**Our ref:** LT/2019/124875/01-L01  
**Your ref:** A38 NSIP  
**Date:** 19 December 2019

### **A38 DERBY JUNCTIONS - RESPONSE TO ISSUES AND QUESTIONS RAISED IN ISSUE SPECIFIC HEARING 2 ON THE 11TH DECEMBER 2019 - ENVIRONMENT AGENCY RESPONSE A38 DERBY JUNCTIONS**

Drawing Title
**FIGURE 10.1
KINGSWAY JUNCTION
GEOLOGY & SOILS STUDY AREA &
FEATURES**

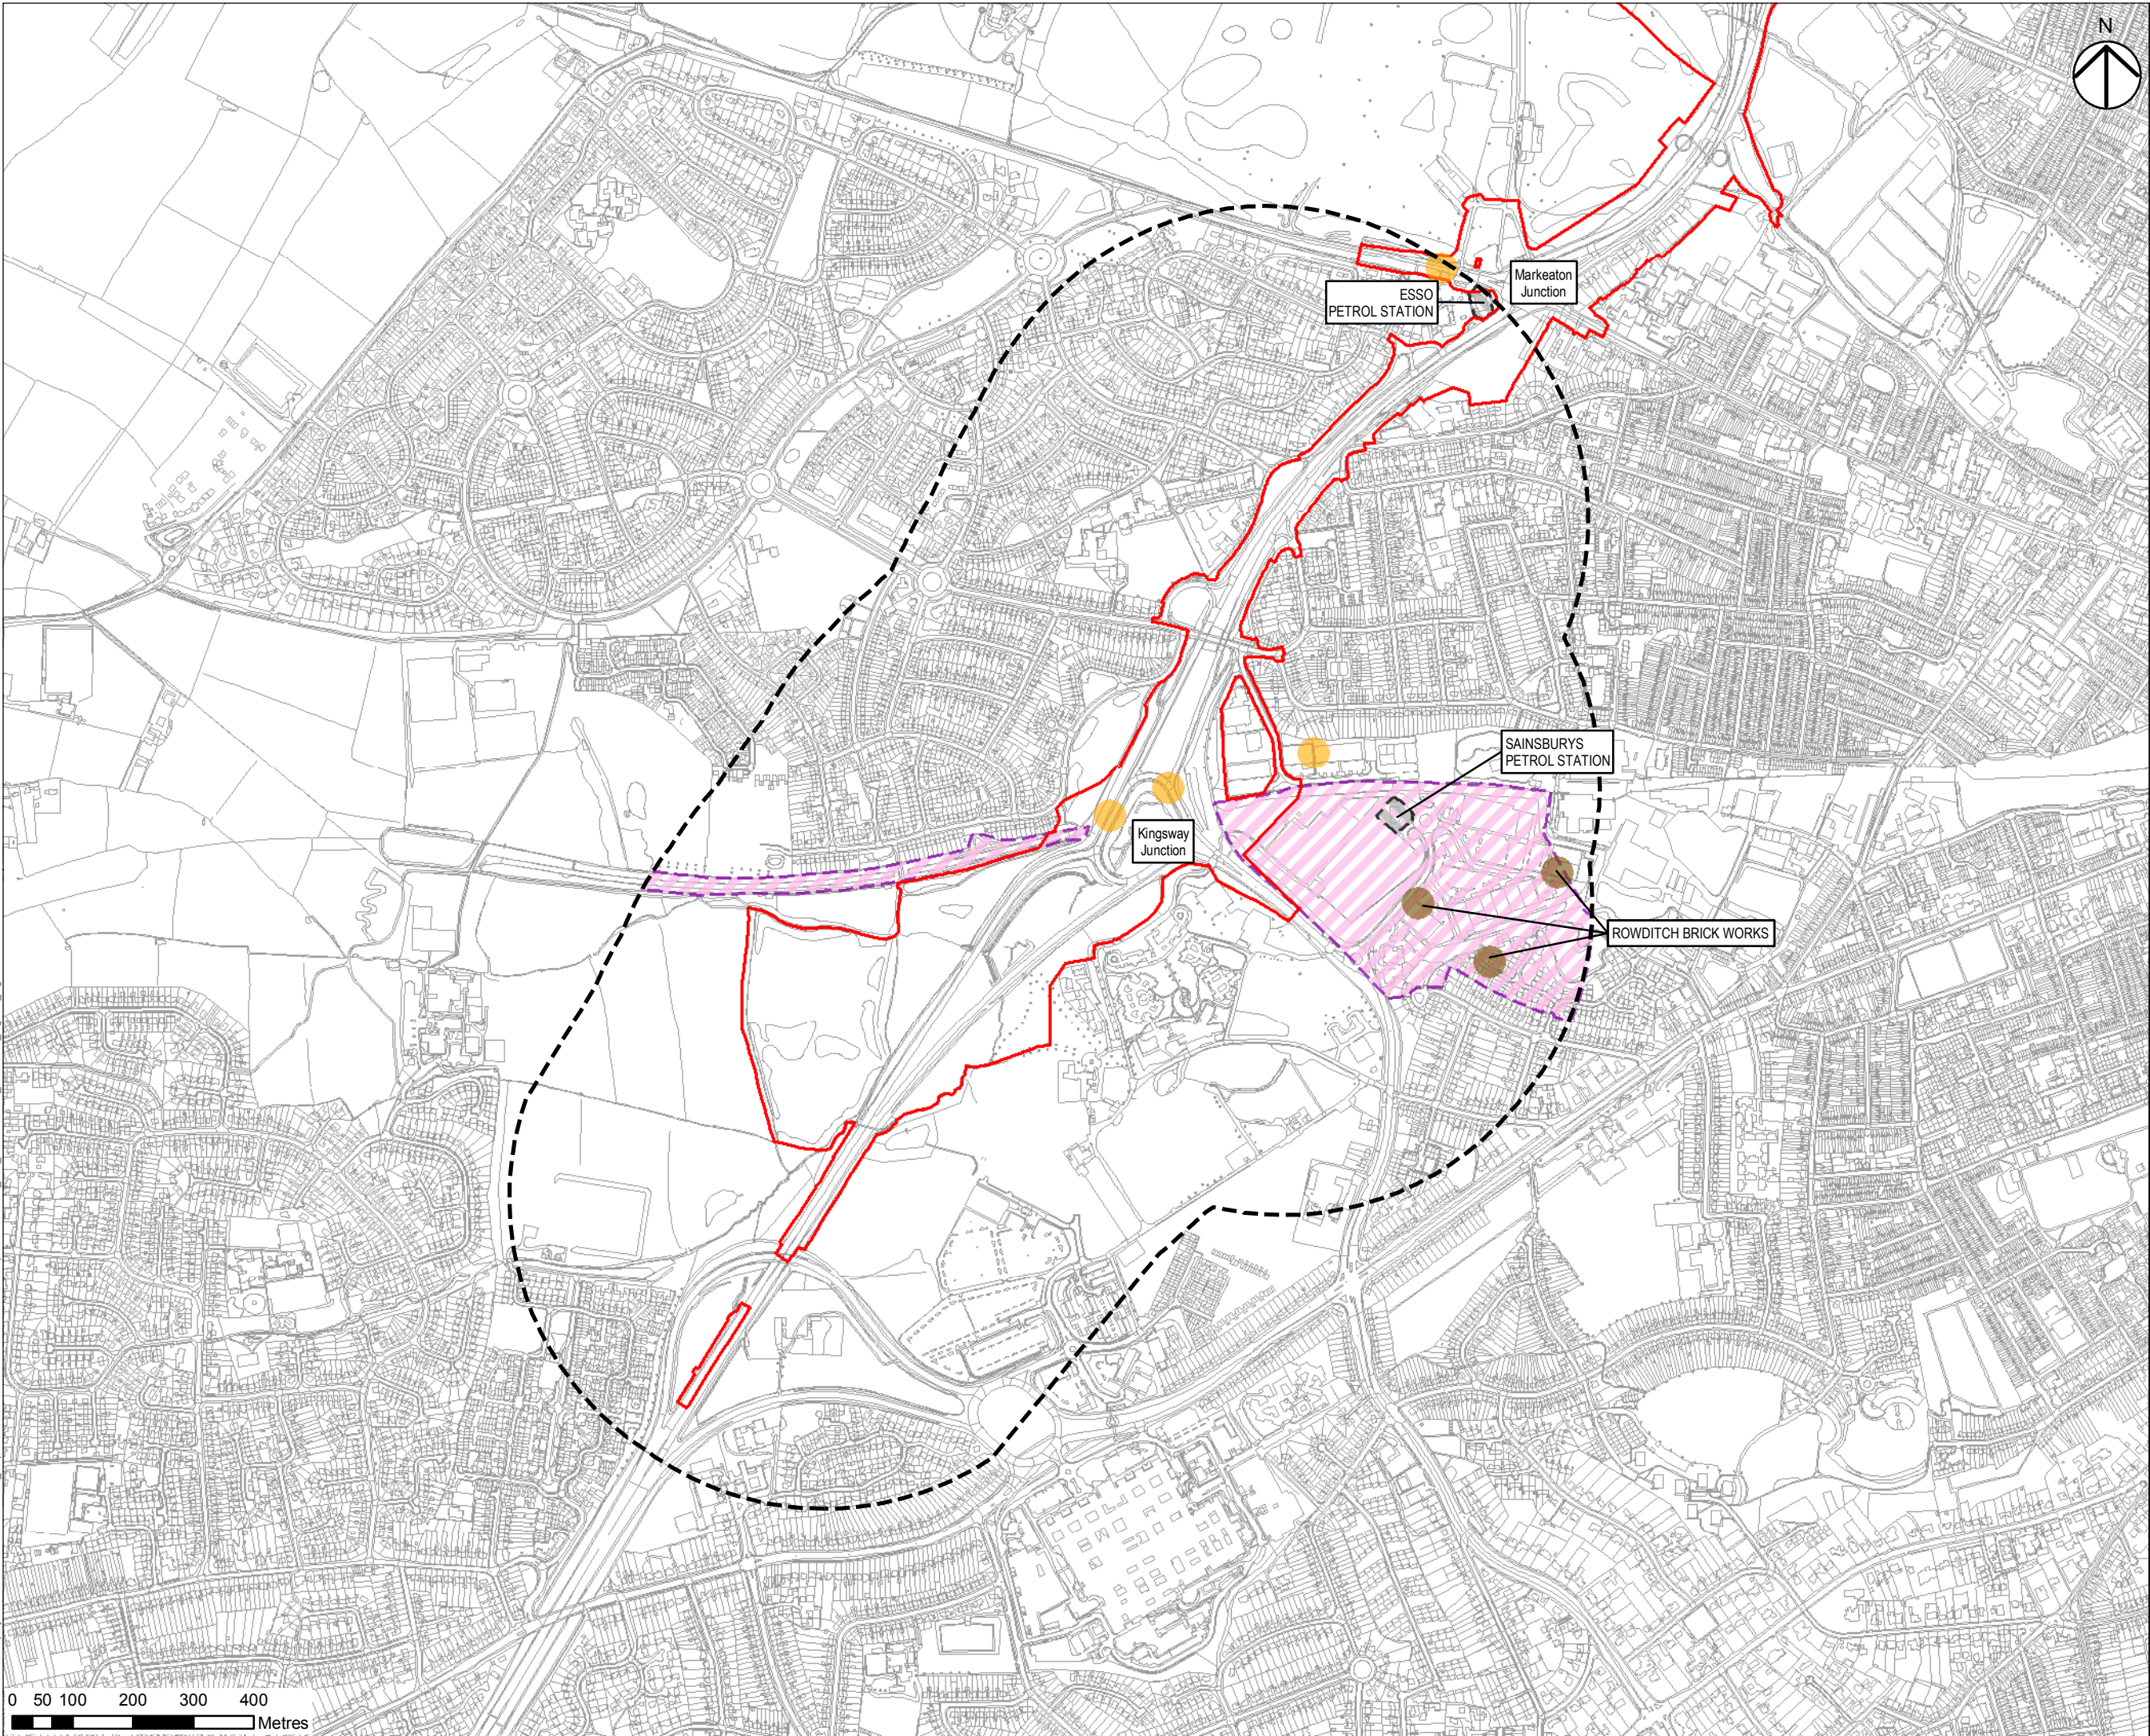
Table 1 indicates that a number of aliphatic and aromatic hydrocarbon bands have been detected in elevated concentrations within groundwater within landfilled materials at the Kingsway Junction. However, there is no subsequent comment or assessment of risk posed to controlled waters receptors from these determinants. This point was raised in paragraph 6.4 of our Relevant Representations (July 2019) and remains an outstanding matter which has not been addressed.

Drawing Title
**FIGURE 10.2
MARKEATON JUNCTION
GEOLOGY & SOILS STUDY AREA &
FEATURES**

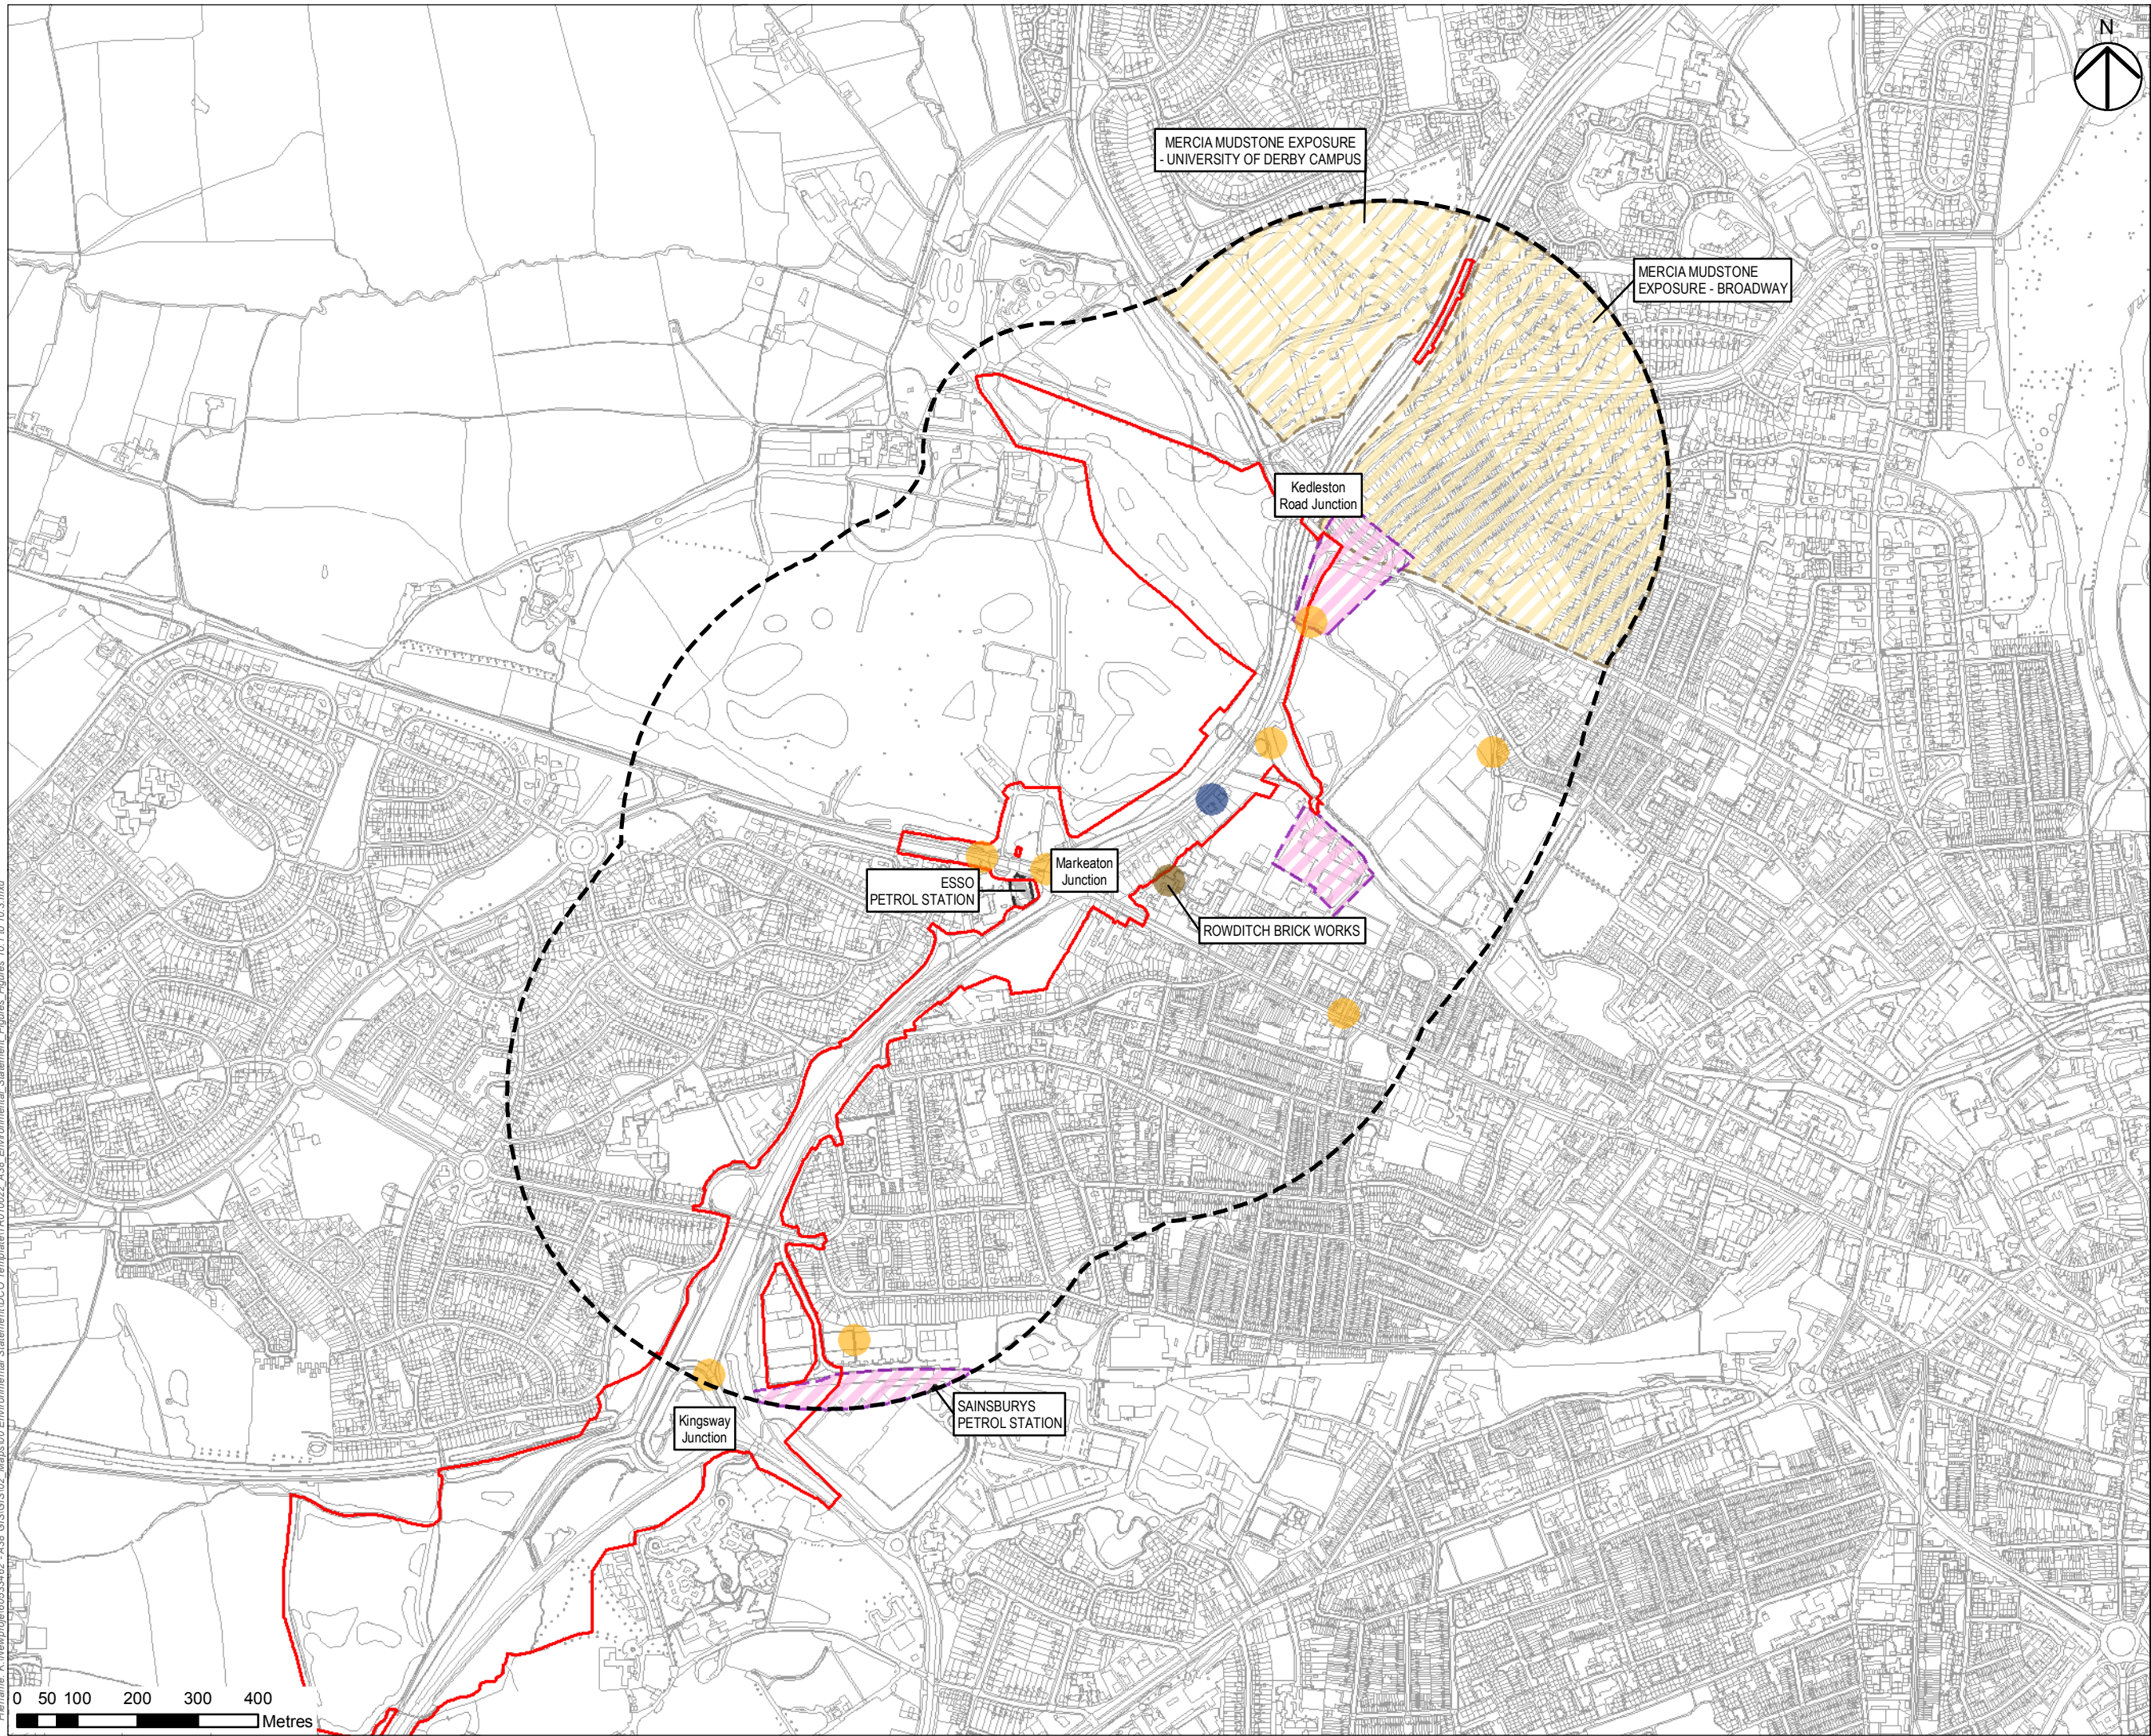
To a lesser extent, similar comments could be made about results of concentrations of similar compounds from groundwater analysis in BM05 within the Markeaton Roundabout area.
